Response to Planning Application

From: Arun District Council Greenspace

Application ref: LU/206/21/RES

Description: Approval of reserved matters following outline consent LU/47/11/ for the development of 261 No. dwellings, the formation of green swale (SuDs feature) and the construction of part of the Central Spine Road running through Phase 5 at Hampton Park and southwards to link up with Toddington Lane. This site is in CIL zone SP2 and is not CIL Liable as strategic site

Phase 5
Materials and
Plant Schedule

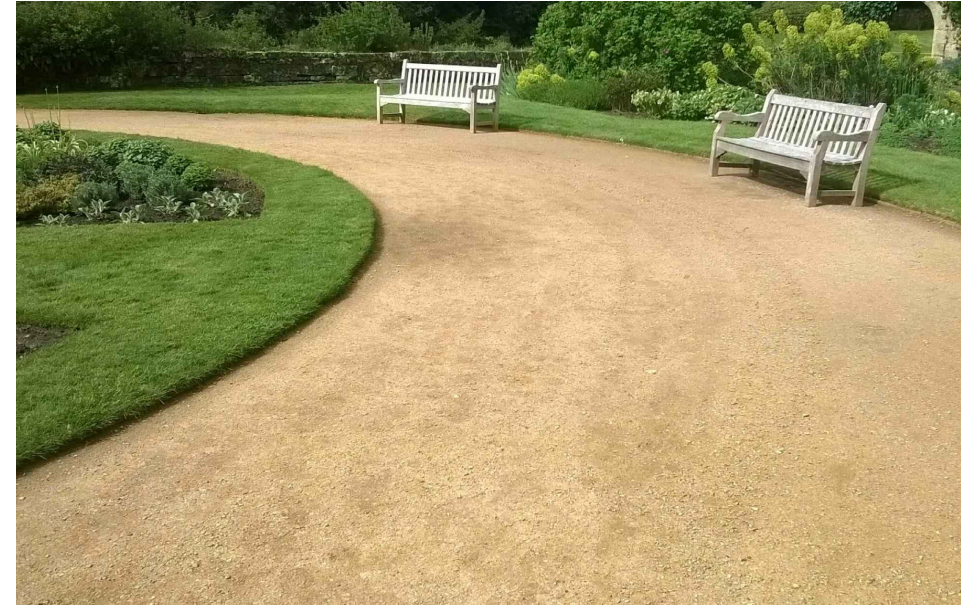
The tree sizes **now specified** have now included species larger than EHS 14-16cm girth at time of planting and now include trees shown within the Material and Plant Schedule LA.PH5.109.REV B at an increased size at time of planting to include Extra Heavy trees 16-18cm girth and Semi mature size trees at 20-25cm girth which will give instant impact and greening to the development and which will require appropriate underground plant support systems detailed and specified for inclusion, and adequate aftercare to ensure establishment.
